Our Ref: WA/84/19/HH

10th October 2019

Installation of wooden fence and driveway gate to replace hedge
Berberis London Road Fontwell Walberton

Scale:
1:50

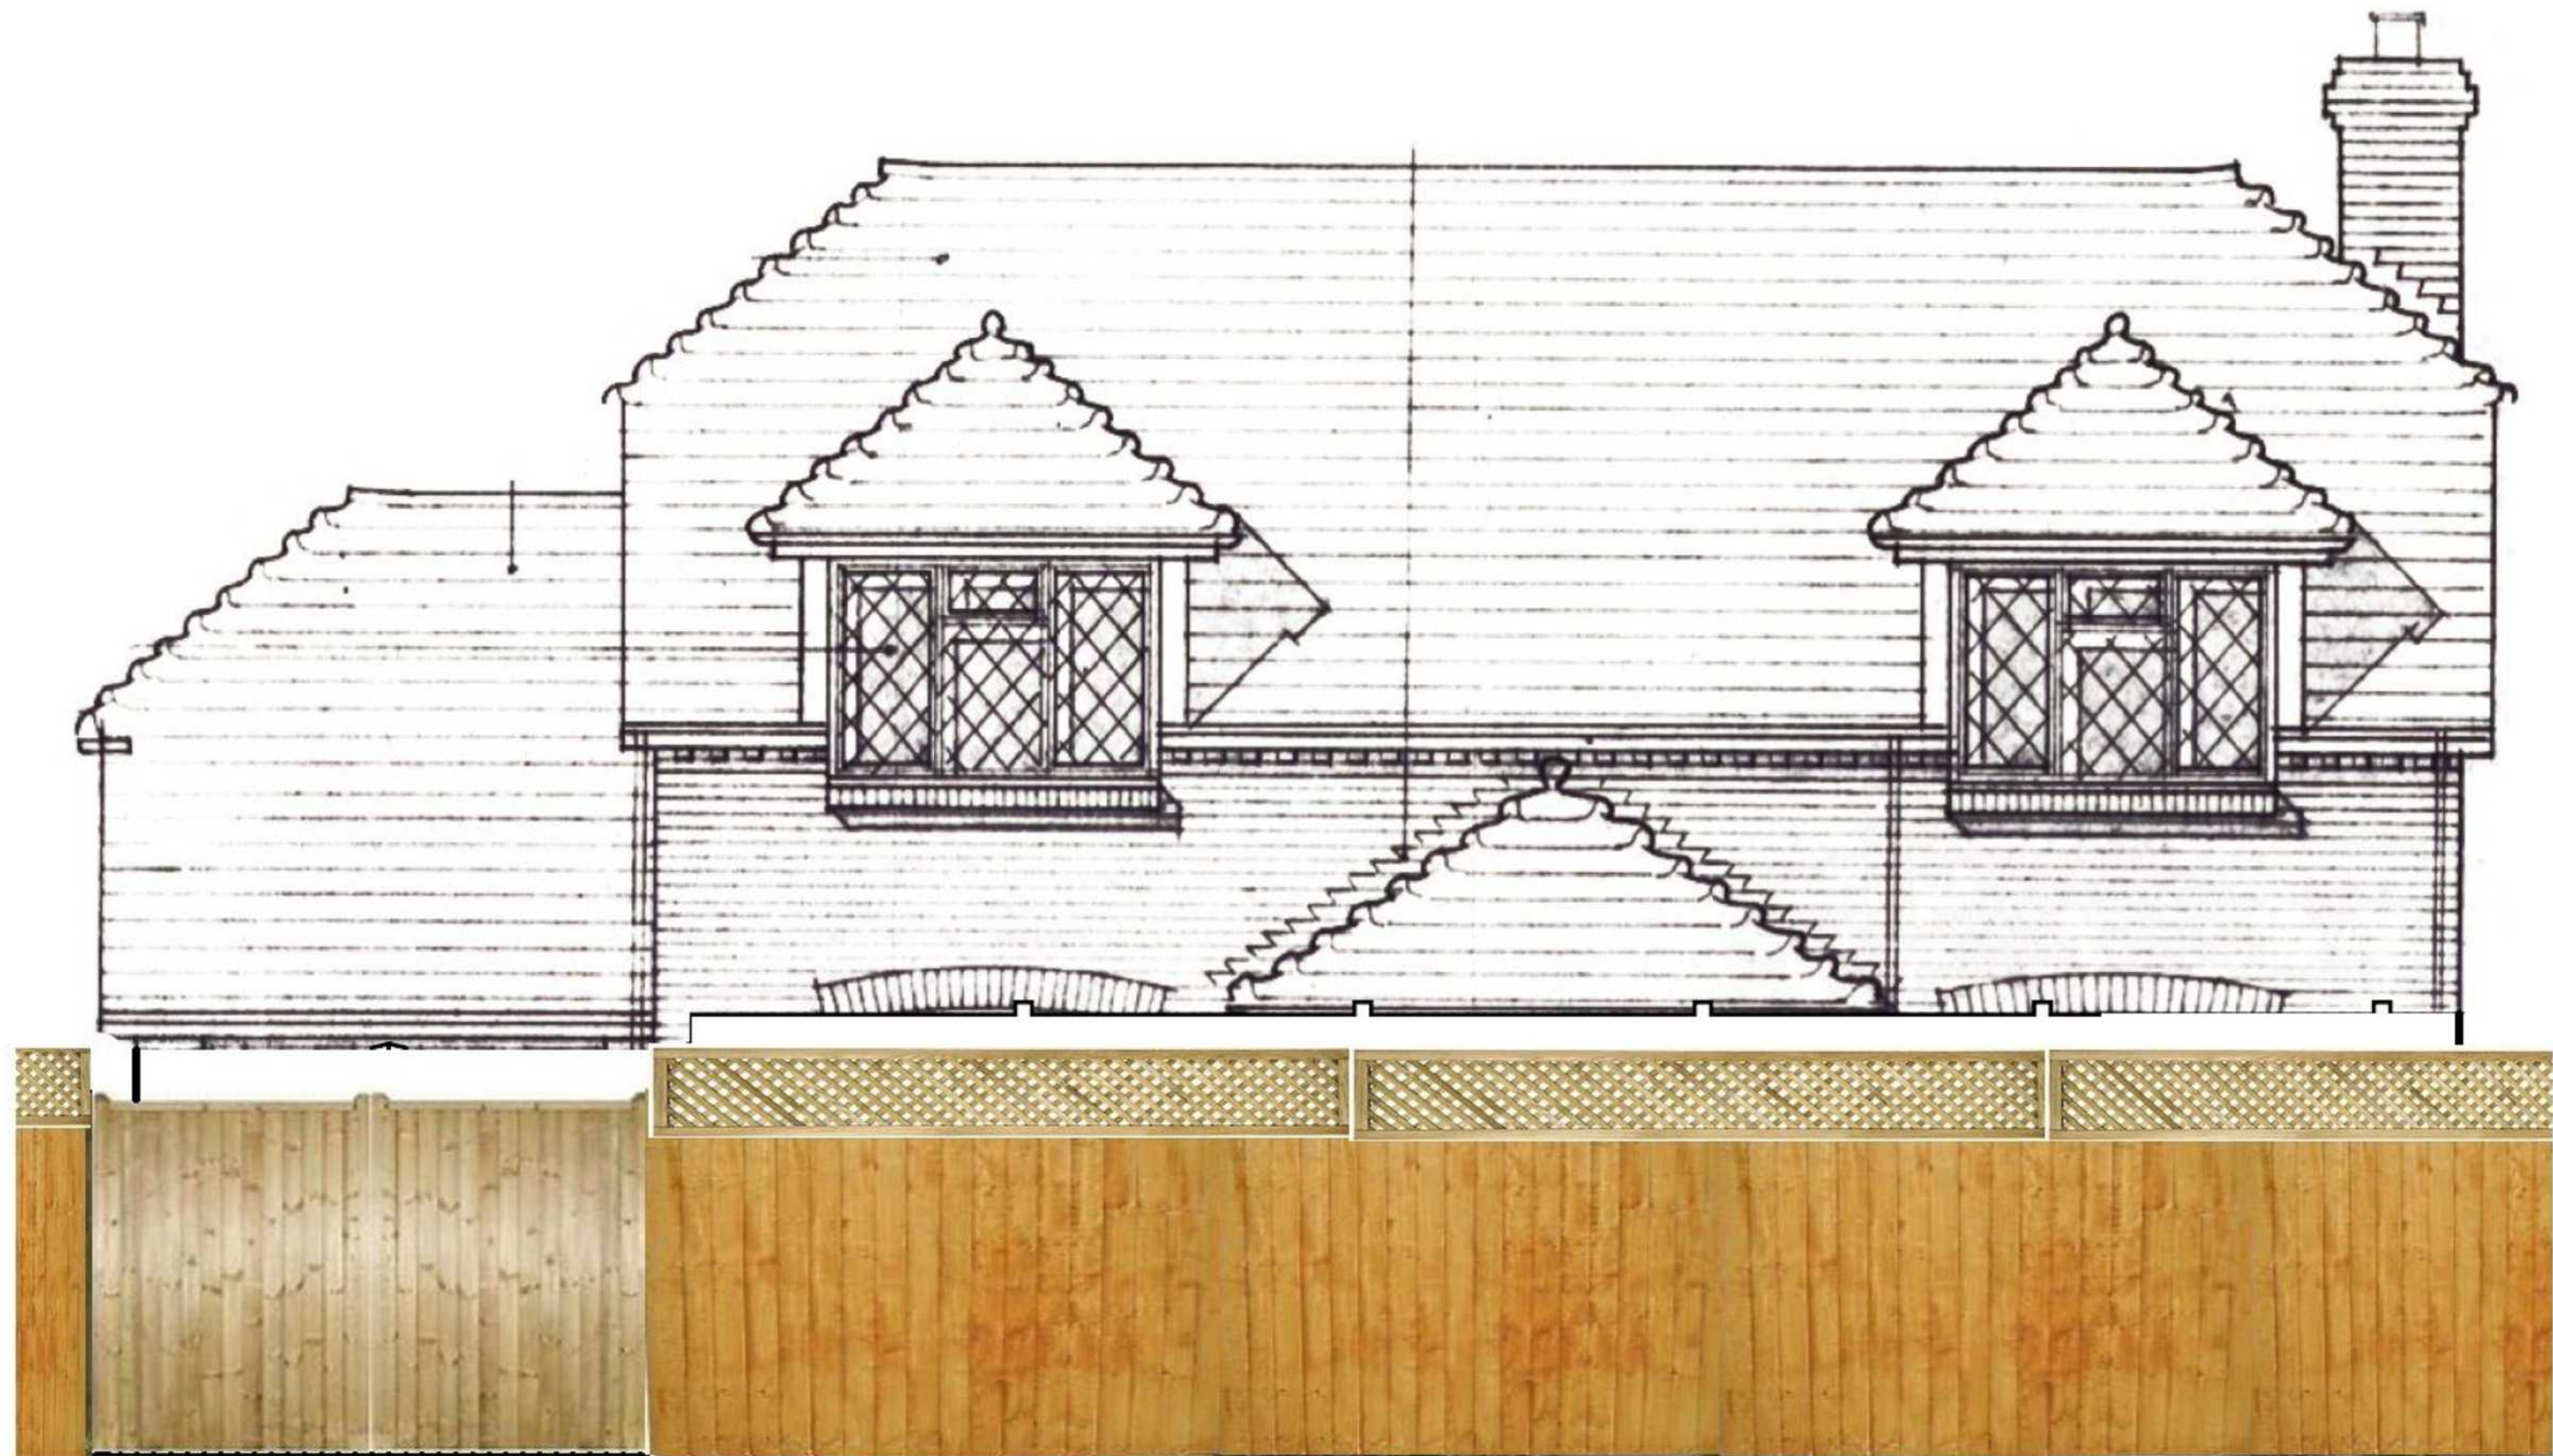
Walberton Parish Council objects to this application on the grounds that the large fence is out of keeping with other property frontages in that area of Fontwell.
